Consultee response

EP/80/20/HH & EP/81/20/L

Vista Point 21 Tamarisk Way East Preston BN16 2TE

Planning and Listed building consent to convert 2 existing garages to habitable accommodation to create a new family living space and enclose the existing outdoor link from the main house to the garage to form an indoor warm/dry link with alterations to the landscaping arrangements.

Drawing number
AA-18064-GA-50-00

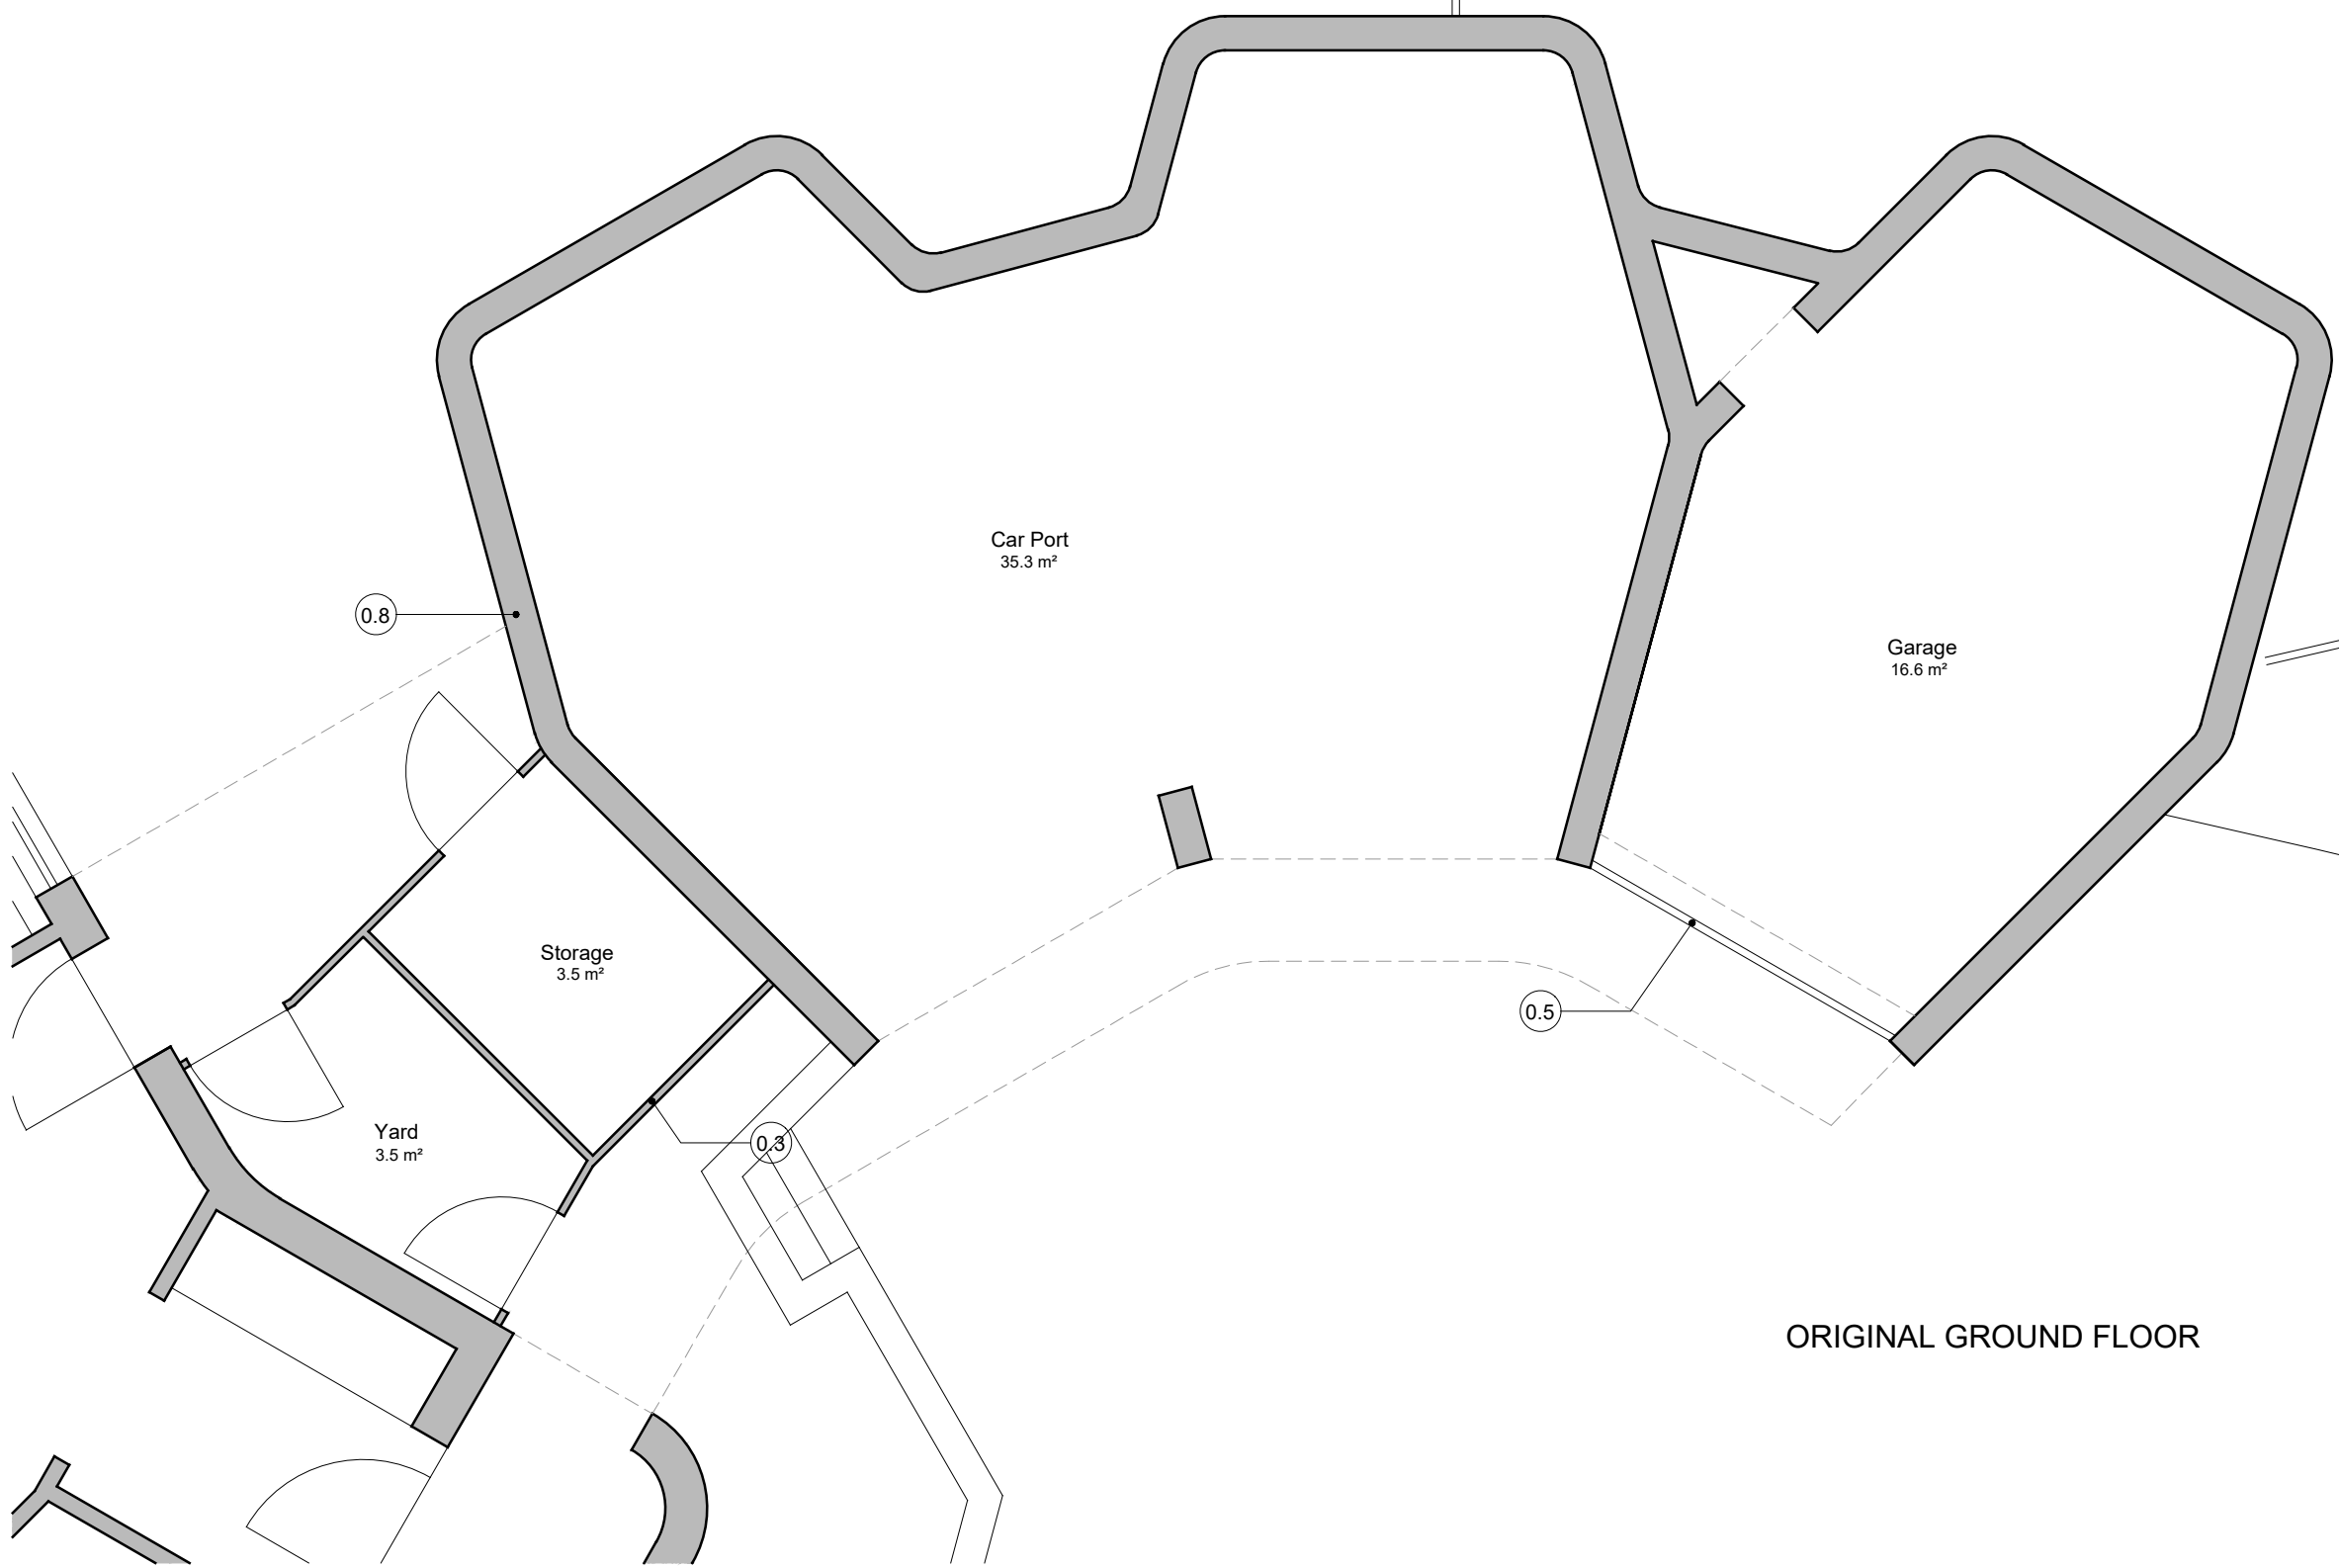
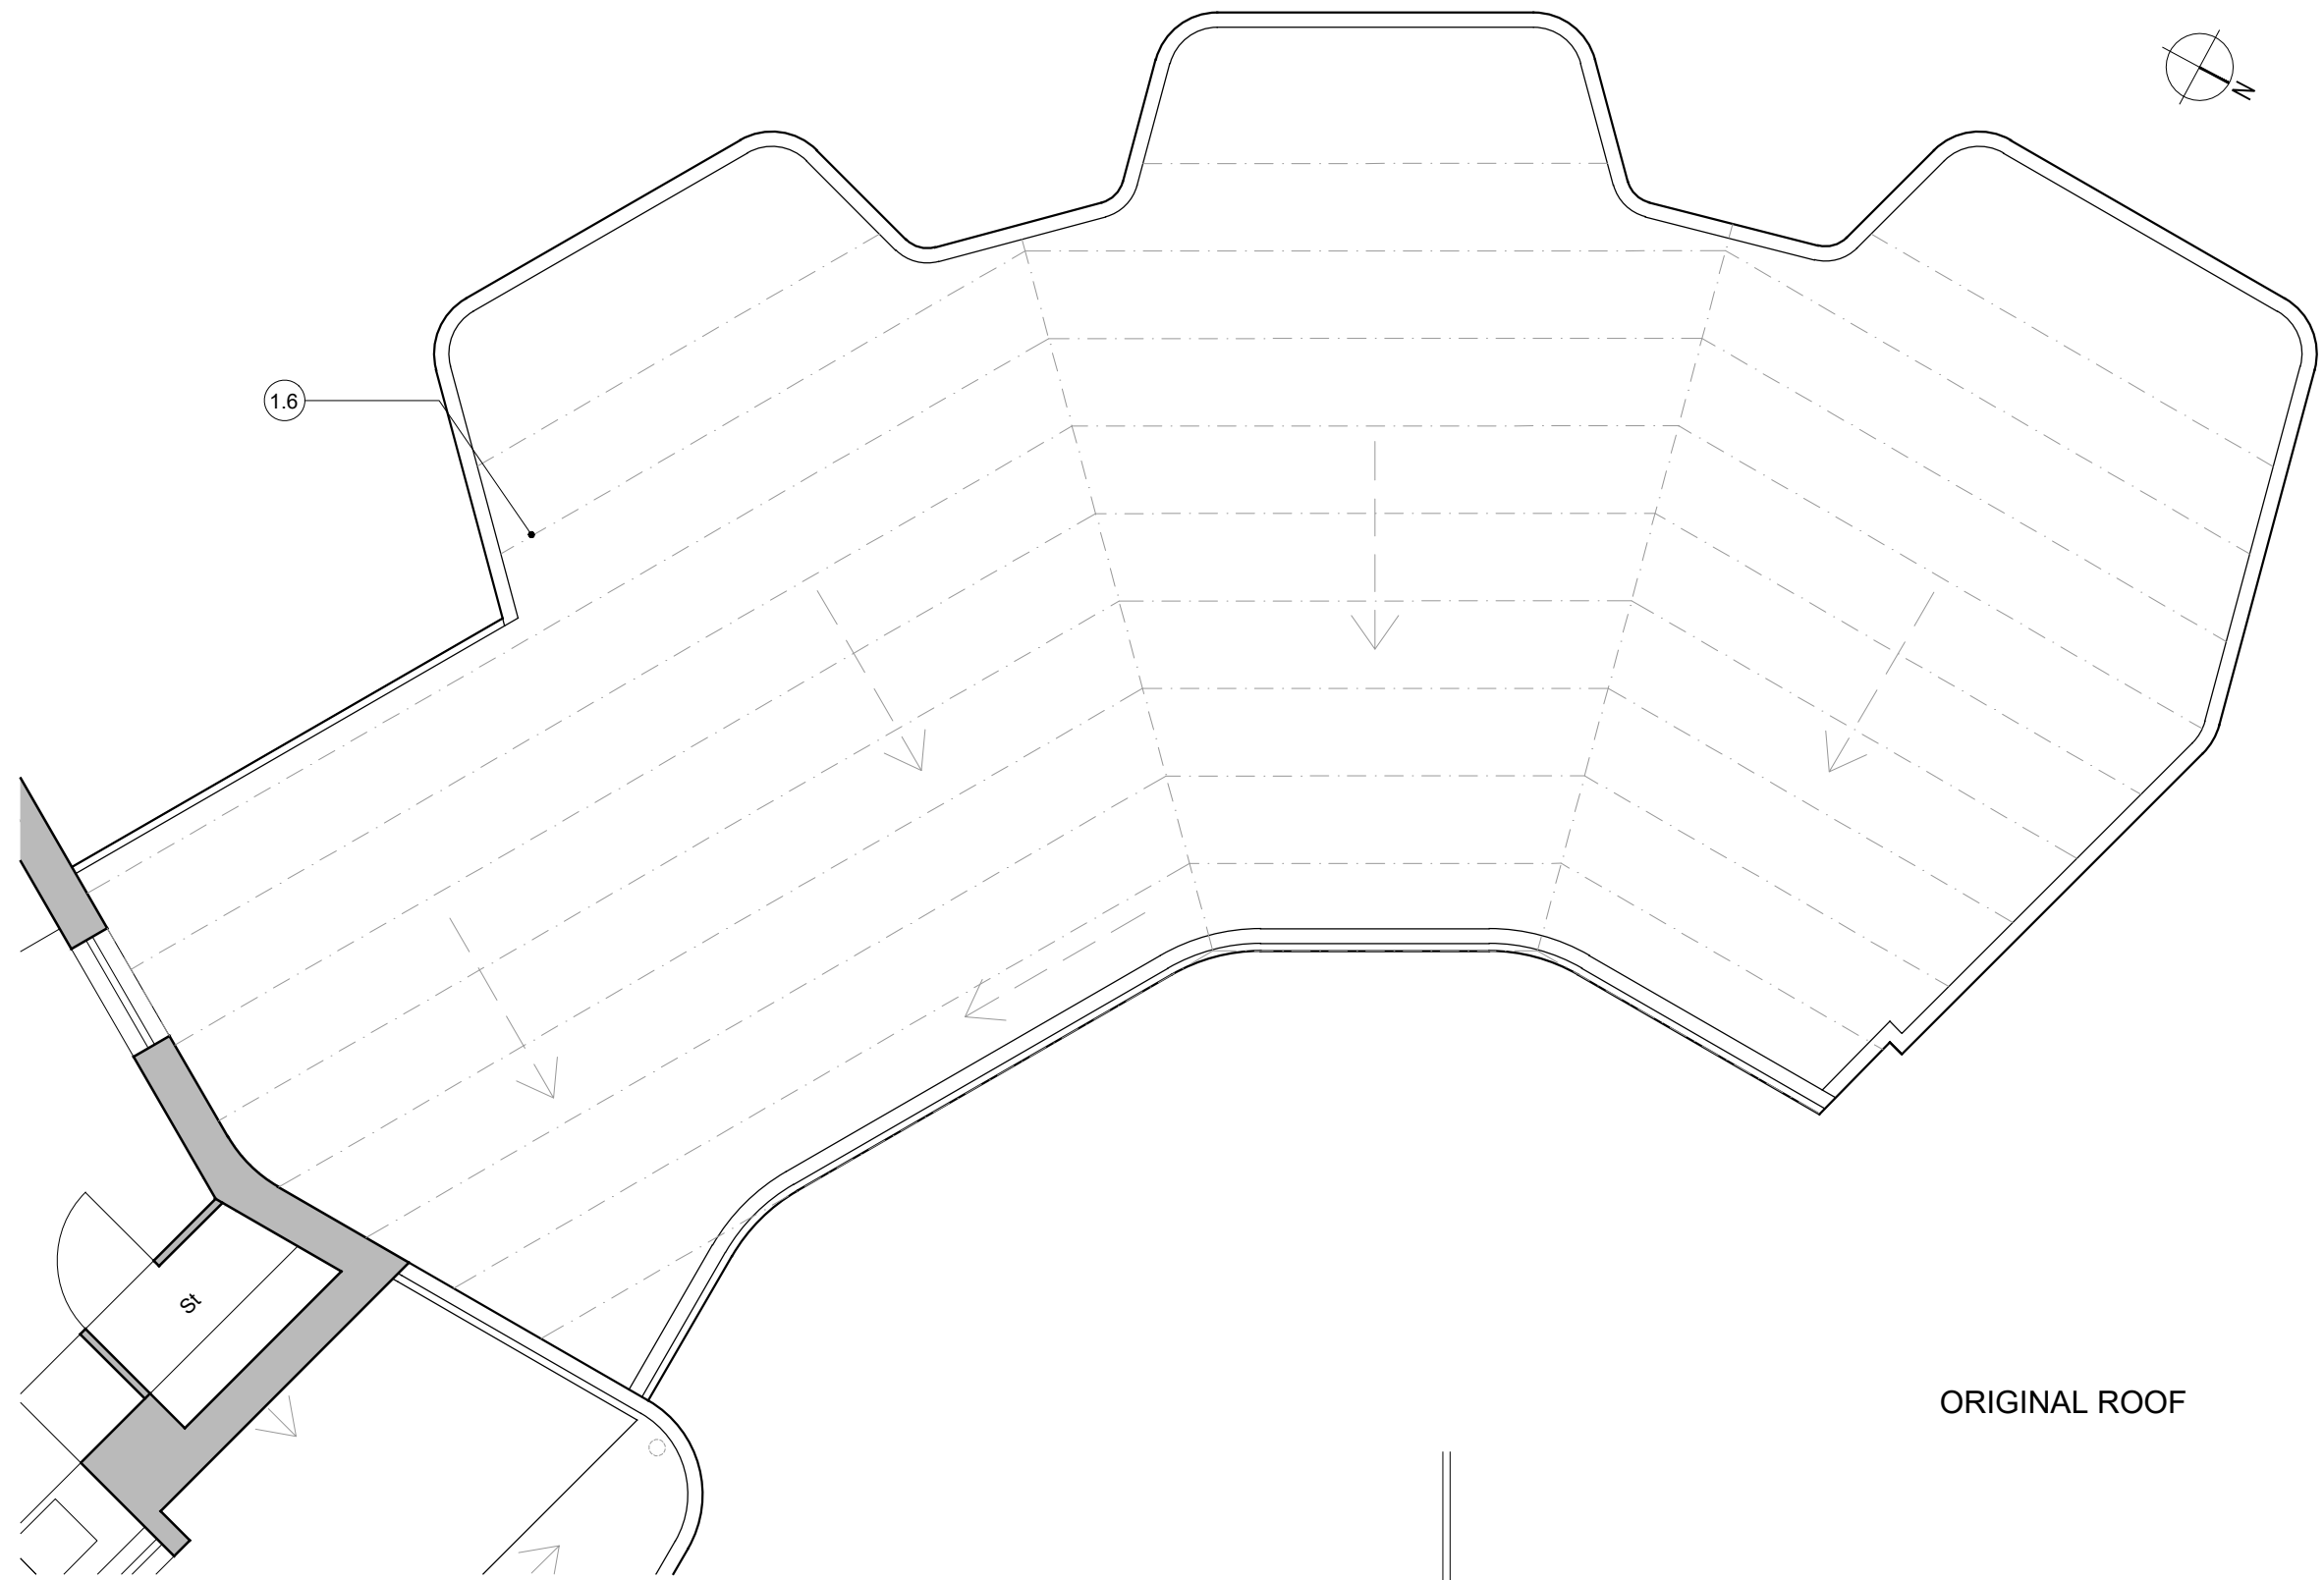
It has been identified that the external appearance of the garage building has altered with the introduction of the two sets of garage doors to the car port. The proposal appears to be for new garage doors to be provided. It is assumed that this is based on the original set, or details based on the original drawing which have been provided?

It is interesting to note on the plans proved that the original garage door remains present (note reference 0.5: Existing original door to garage). This is helpful as it indicates what the proposed new double doors could look like for the games room element of the building. It is also not clear why the original garage door is to be replaced? Is it in a poor state of repair, and unable to be salvaged?
